Town & Country Planning Act 1990 (as amended)
Town and Country Planning (Development Management Procedure) (England) Order 2015
Approval of details reserved by conditions imposed under P/107/16/PL relating to conditions 3-
surface water drainage, 4-schedule of materials & finishes, 5-landscape scheme, 6-screen
wall/fence details, 8-site set up during construction, 10-storage of waste & recycling details , 11-
placement of 2 No. nesting opportunities for birds & 14-external lighting details.
7 Webb Close Pagham,,

Notification regarding the above application:

Arun District Council have decided to **REFUSE details reserved by condition for the following reasons:**

PROPOSED
SITE PLAN

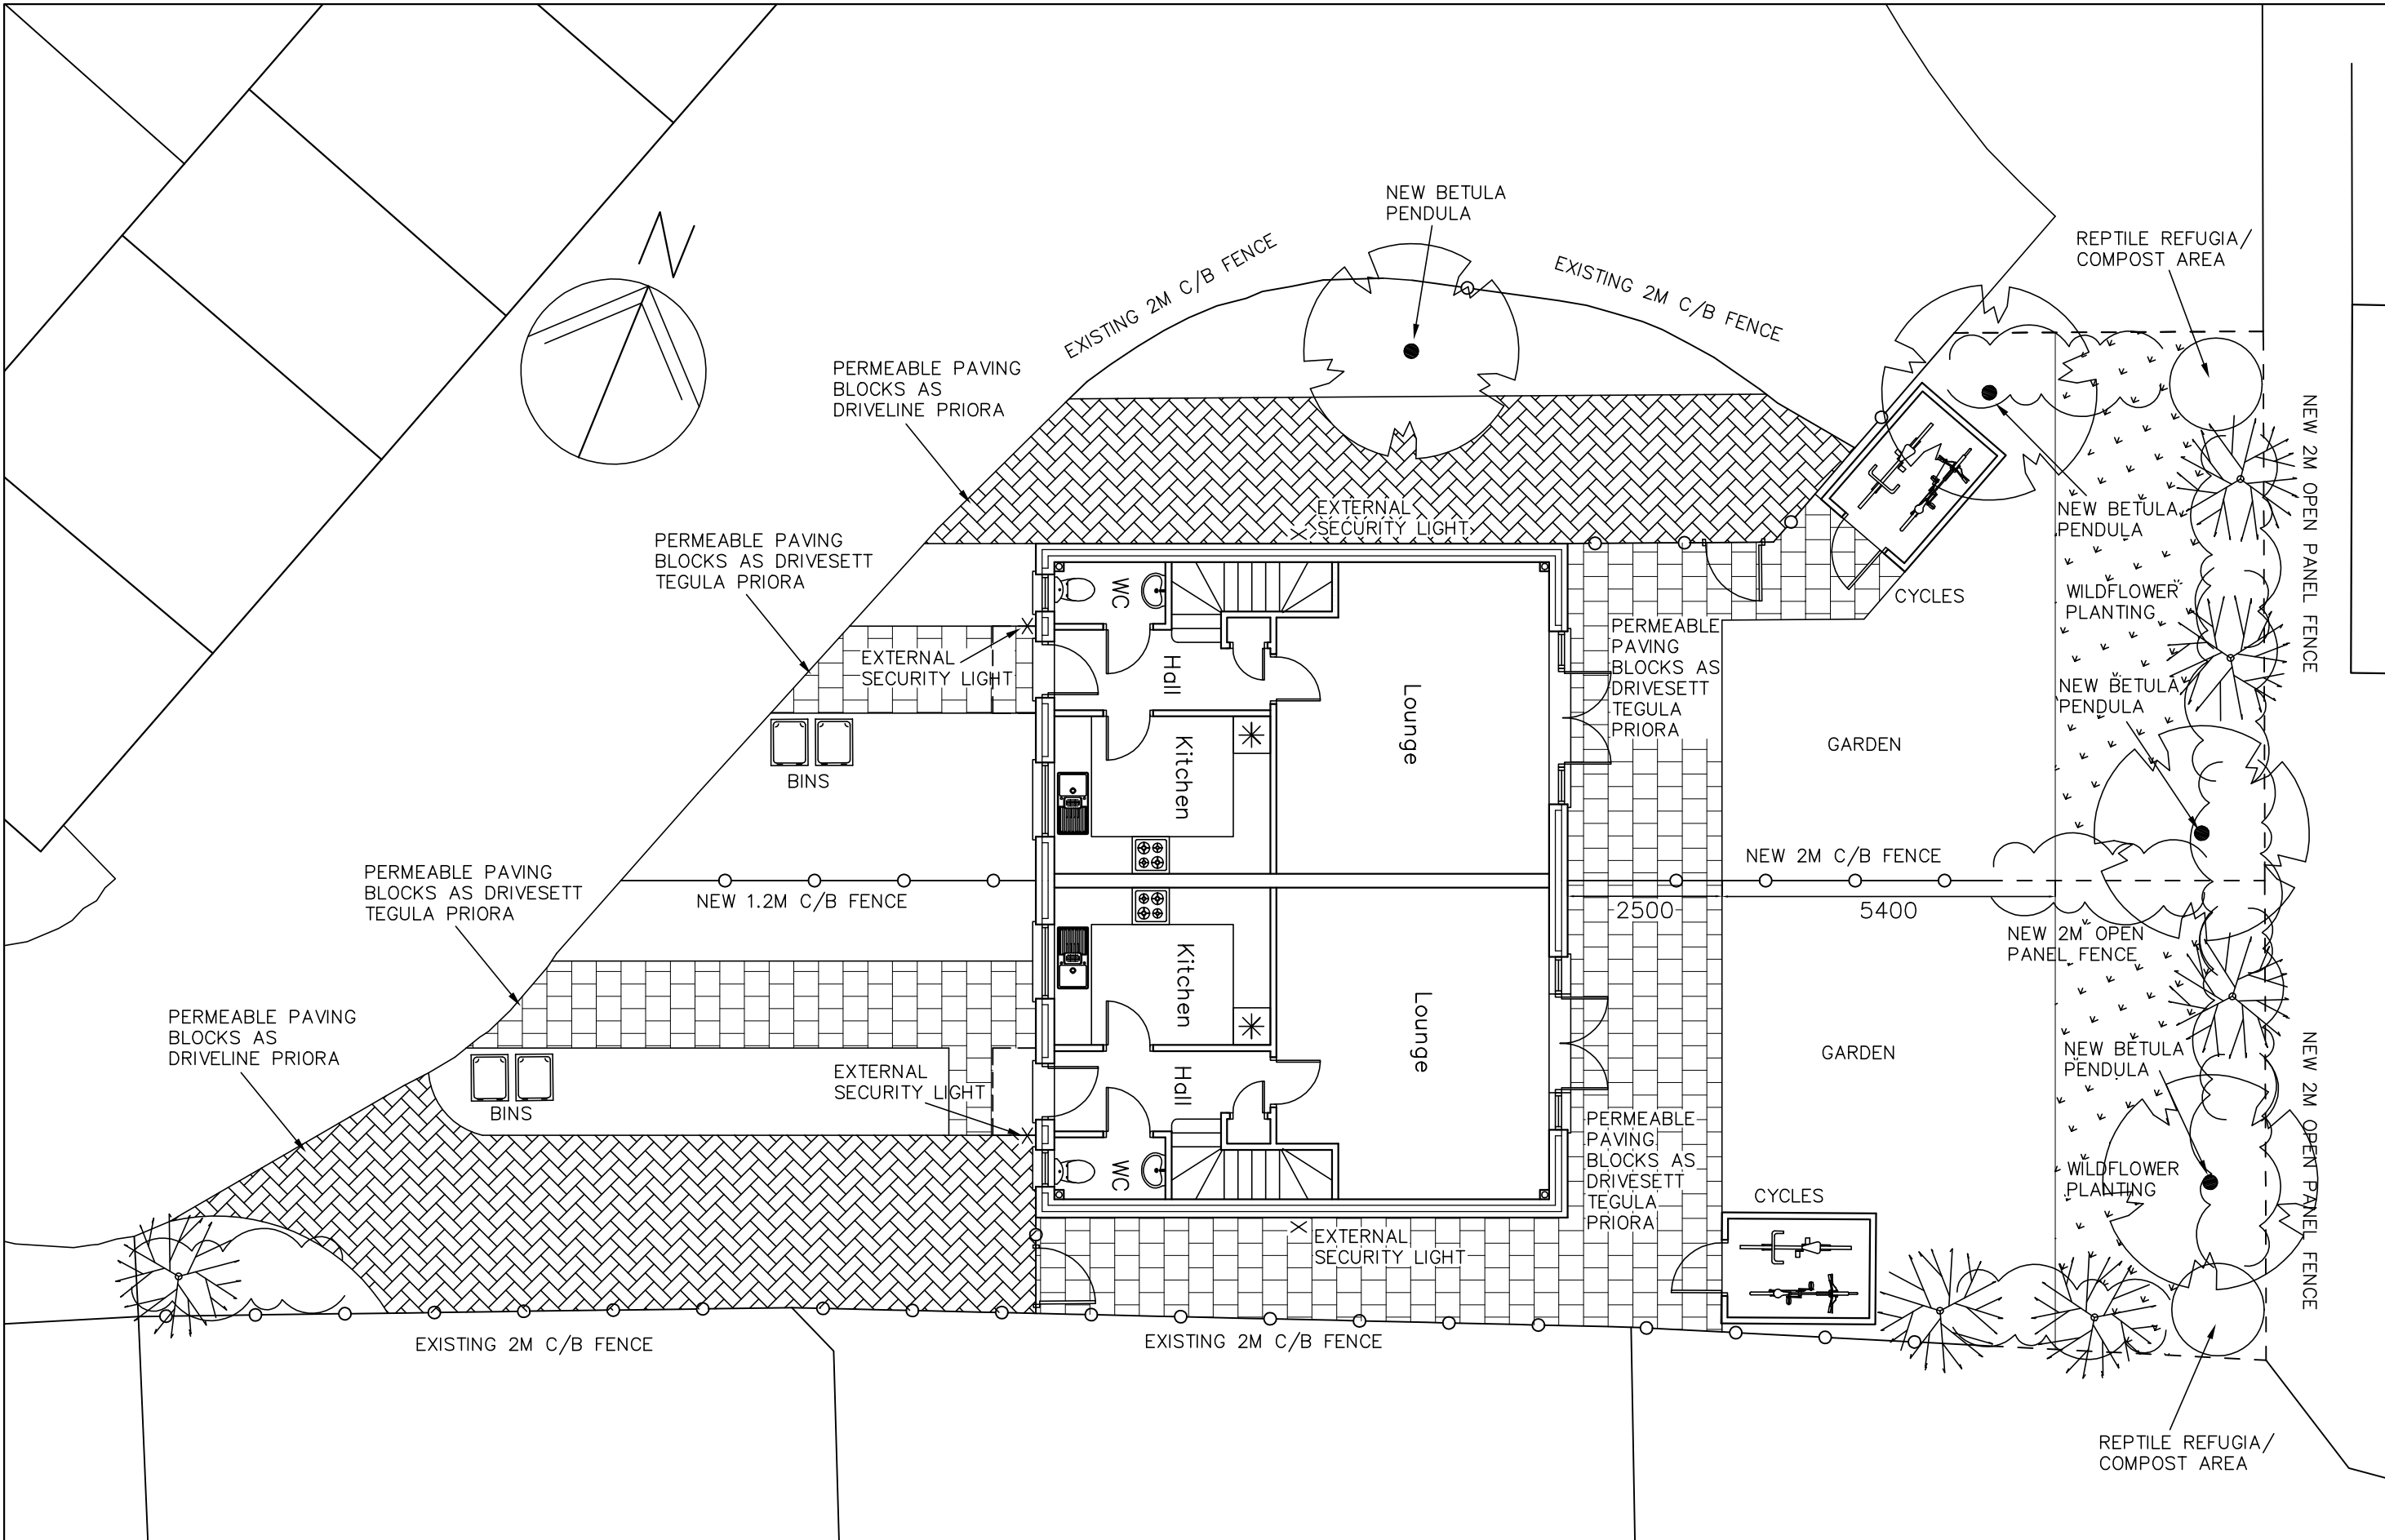
"Unfortunately the suggested outside lighting will produce up and down lighting which could cause a disturbance to bats using the area for foraging and commuting. We require that the lighting scheme should minimise potential impacts to any bats using the trees, hedgerows and buildings by avoiding unnecessary artificial light spill through the use of directional light sources and shielding."

We wrote to you on the 9th March to make you aware of the need for a revised scheme. However, to date, no further details have been provided. As such, the condition cannot be discharged and you will need to make a revised submission.
